WEST SUSSEX COUNTY COUNCIL CONSULTATION

TO:	Arun District Council FAO:Mr S Davis
FROM:	WSCC - Highways Authority
DATE:	29 July 2019
LOCATION:	Rear of Inglenook Hotel 253-255 Pagham Road Bognor Regis PO21 3QB
SUBJECT:	P/58/19/PL Erection of 9 No. dwellings with associated access, parking, cycle & refuse storage & landscape design. This application is a Departure from the Development Plan & may affect the setting of a listed buiding.
DATE OF SITE VISIT:	N/A
RECOMMENDATION:	More Information
S106 CONTRIBUTION TOTAL:	£ See below for breakdown.

Drawing Title
Refuse Vehicle Access and Egress
and Concurrent Car's Movements

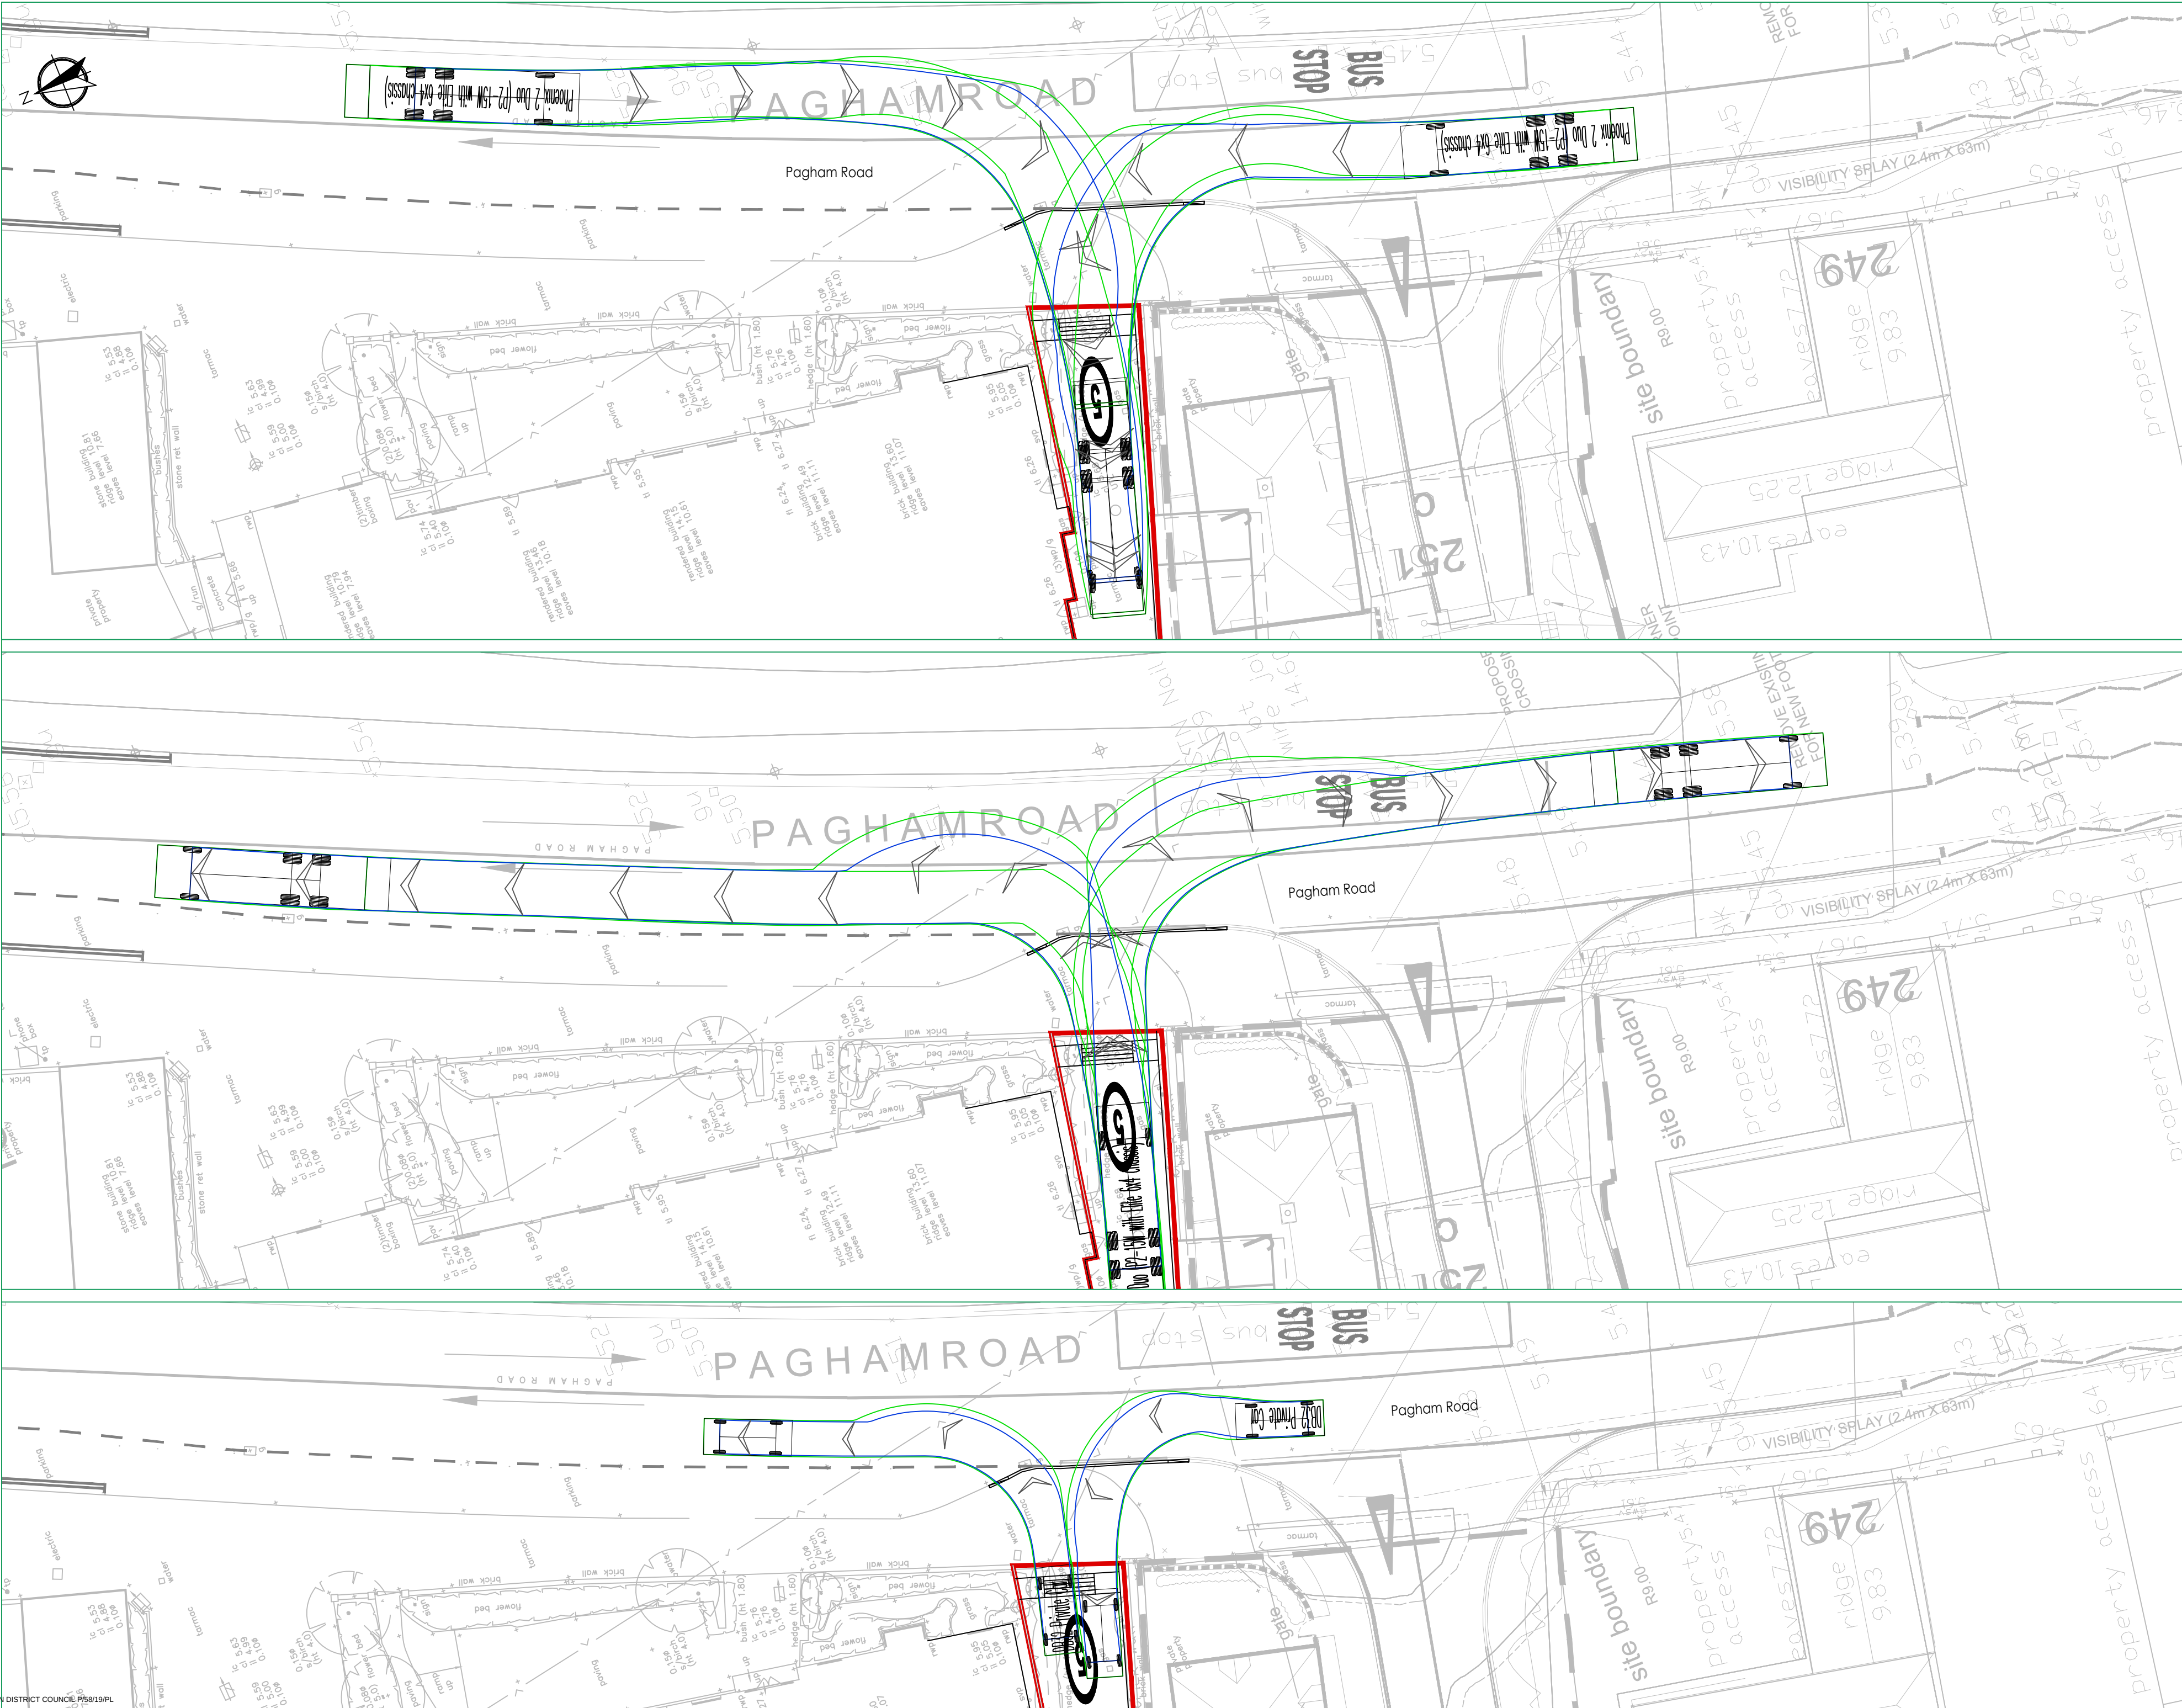
I note that the pre application advice issued by the LHA in 2017 advised that the Refuse and Recycling authorities should be consulted regarding the access arrangement for the refuse lorries. It is unclear whether this has taken place and whether the Recycling and Refuse authorities would be supportive of this narrow access arrangement.

Please provide any comments and details issued by the refuse and recycling authorities regarding the use of this narrow access arrangement.
